REF: Planning Application 20/01747/F: Land South Side Of Widnell Lane Piddington: Change of Use of land to a 6no pitch Gypsy and Traveller site to include 6no mobiles, 6no tourers and associated operational development including hardstanding and fencing.

I object to this new application 20/01747/F on the following grounds:-

# Proposed Block Plan

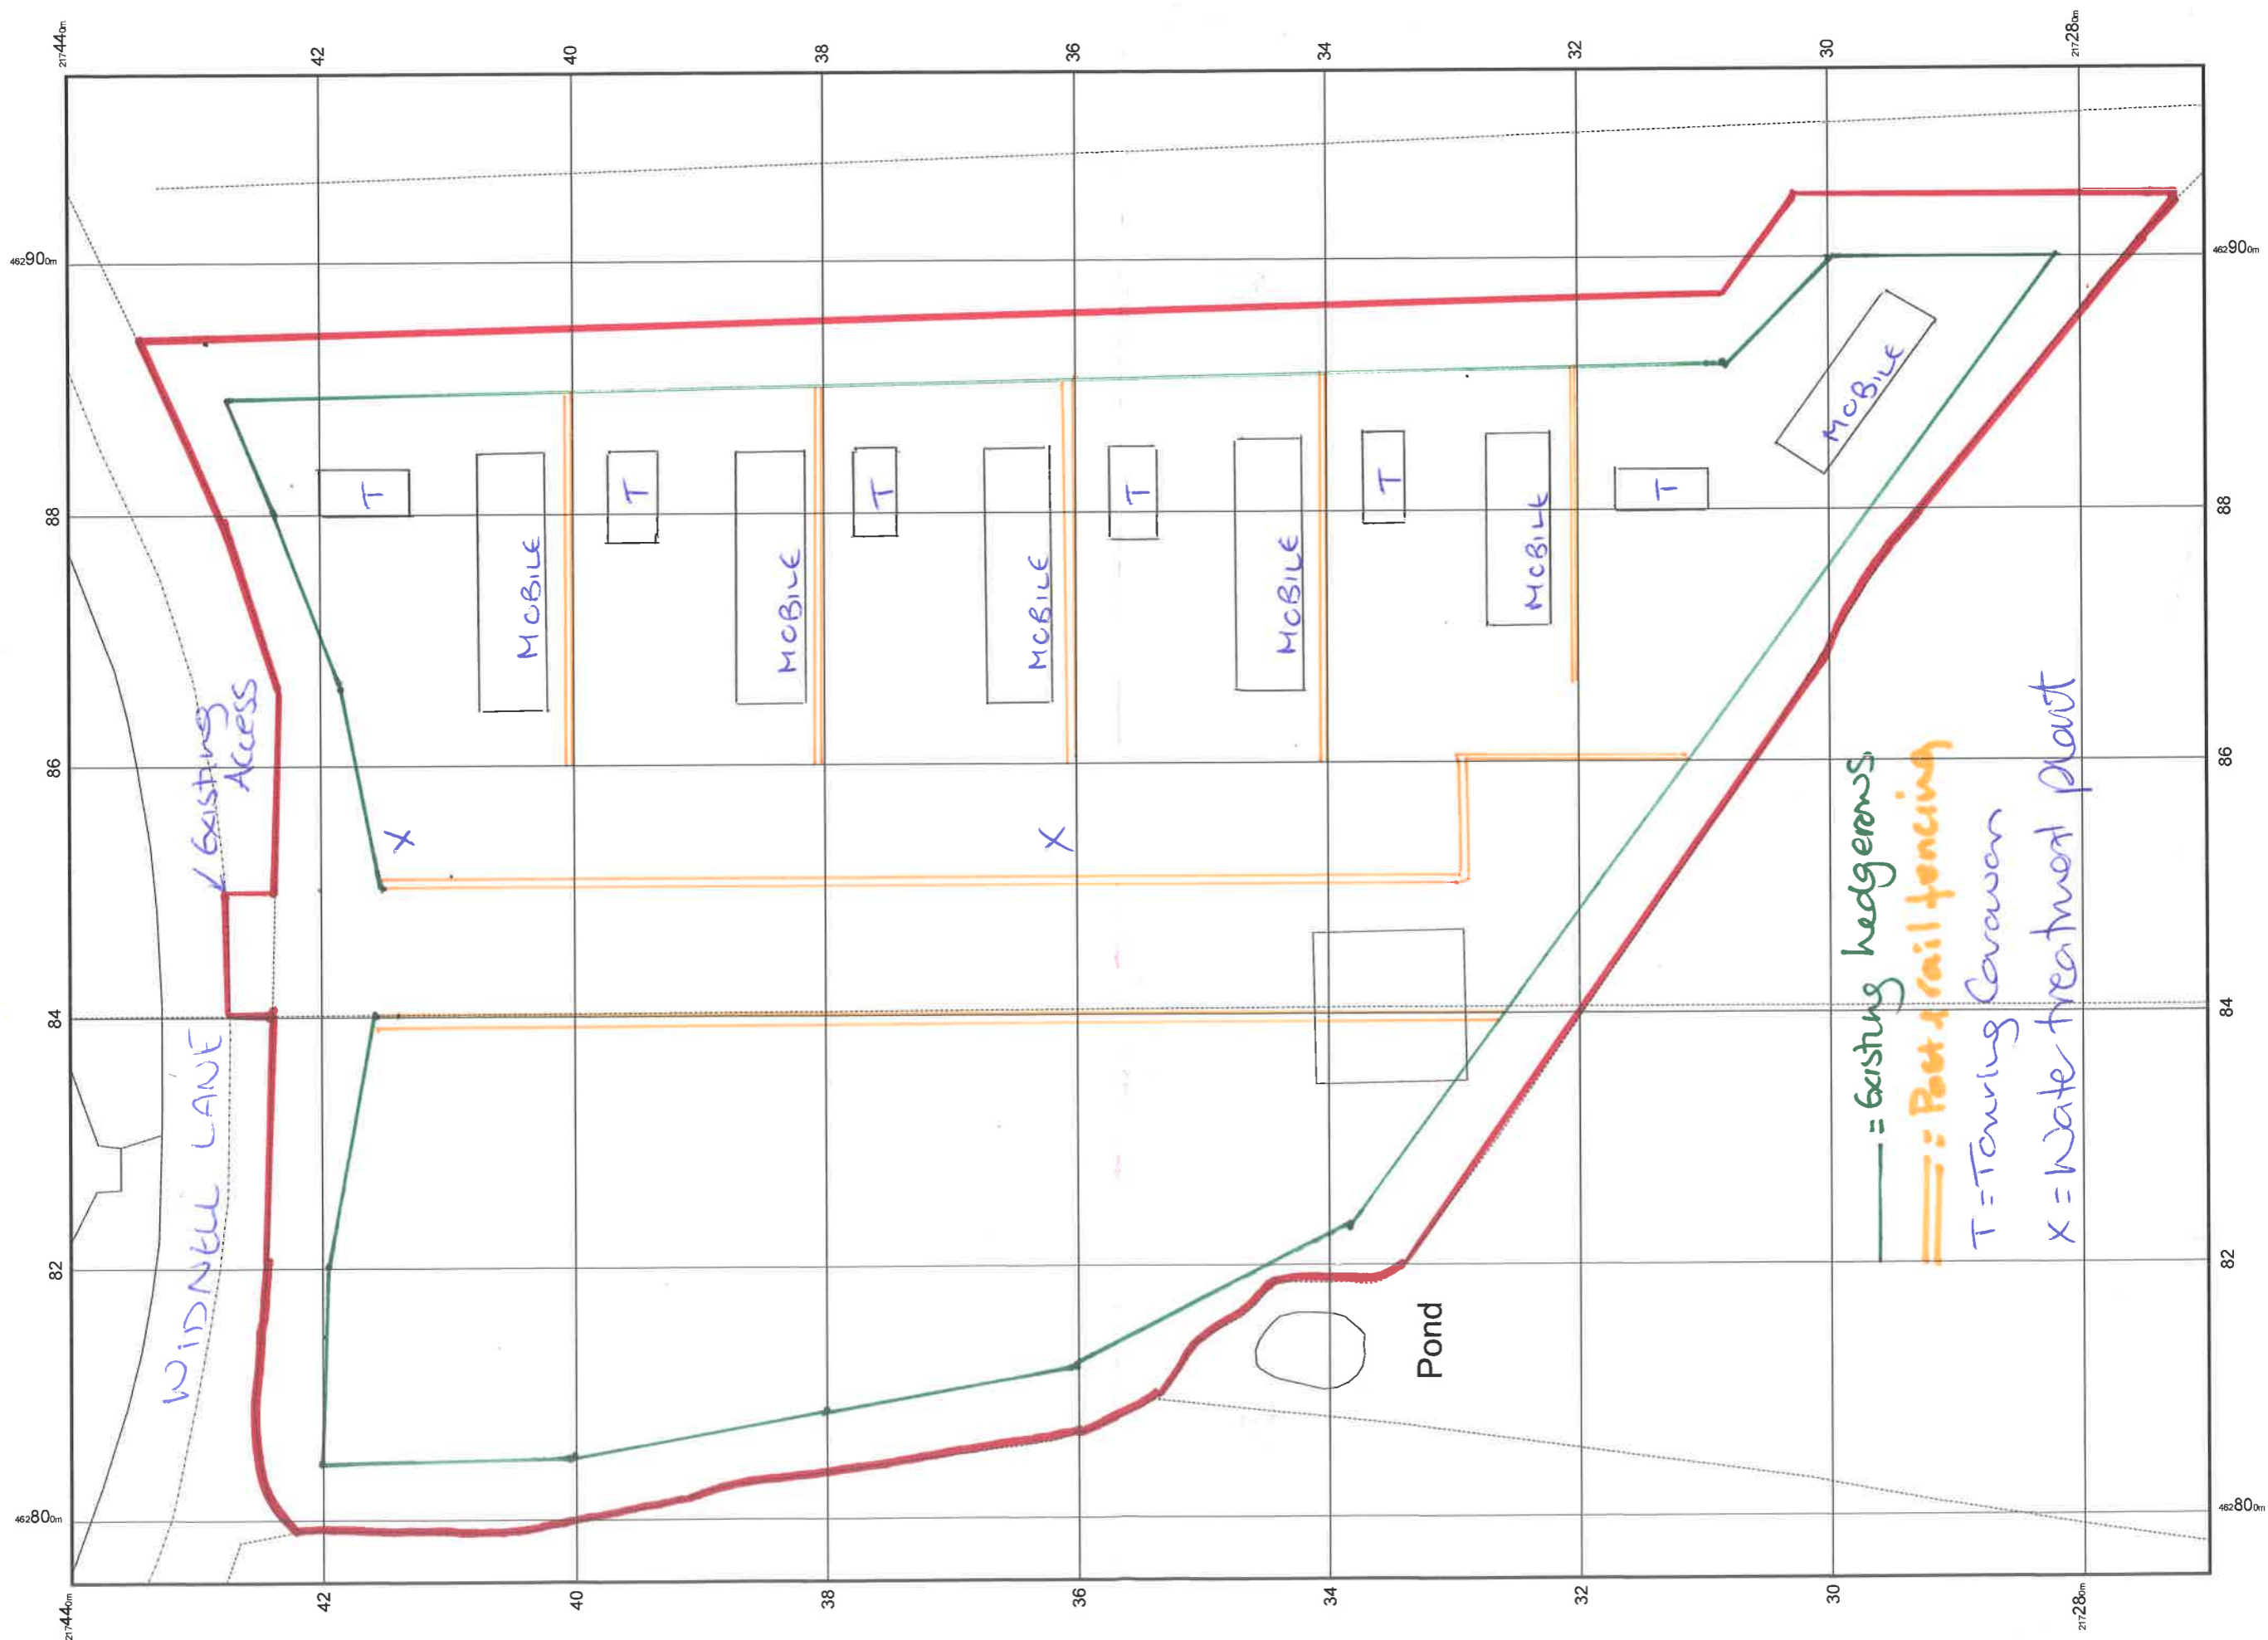
- no provision for adequate parking spaces
- no turning space
- no provision for recycling storage and collection from site
- no attempt to minimise noise and light pollution from the site
- no details are supplied as to the “*lamppost style light per pitch*”. Any lights will be dominant in the rural area and will adversely affect the enjoyment of many properties as Piddington is a linear village and the lights will be just a few fields away.

The Block Plan submitted identifies an 'Existing Entrance' for application 20/01747/F. Please note that there is NO EXISTING ENTRANCE onto Widnell Lane from this parcel of land. The only entrance is on the land associated with the active application 20/01122/F.
